**Subject:** WA/94/19/NMA, WA/95/19/DOC and WA/96/19/DOC - Land East of Tye Lane, Walberton

Please find attached a document which includes 4 annotated Public Open Space Plans identifying additional landscaping along the northern boundary of the site with Avisford Park Golf Course.

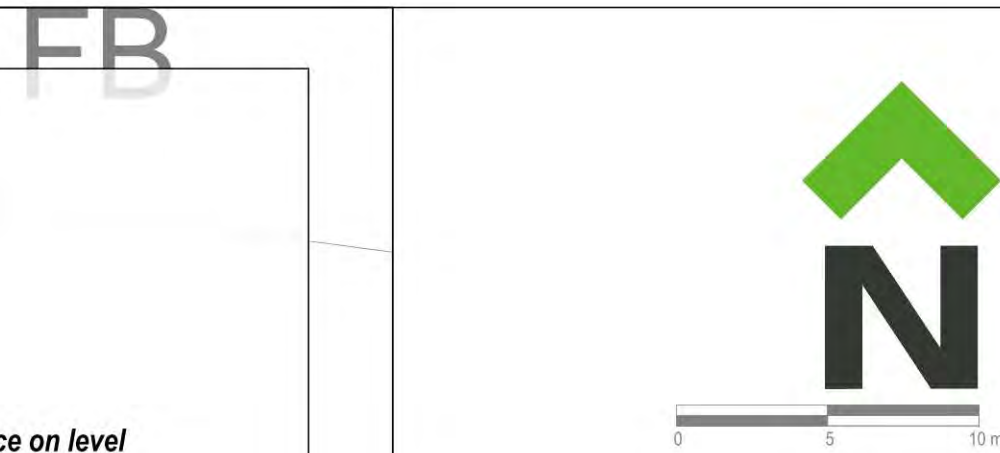
Could the additional planting be shown on all of the Public Open Space and landscaping plans and be submitted as a matter of urgency for **WA/94/19/NMA**, **WA/95/19/DOC** and **WA/96/19/DOC** - Land East of Tye Lane, Walberton.

Hi Michael – yes I agree to the extension of time. Our landscape consultant is reviewing the plans to see where we can add some areas of additional landscaping within the constraints. I have asked for this asap and will keep you updated on when you can expect it.
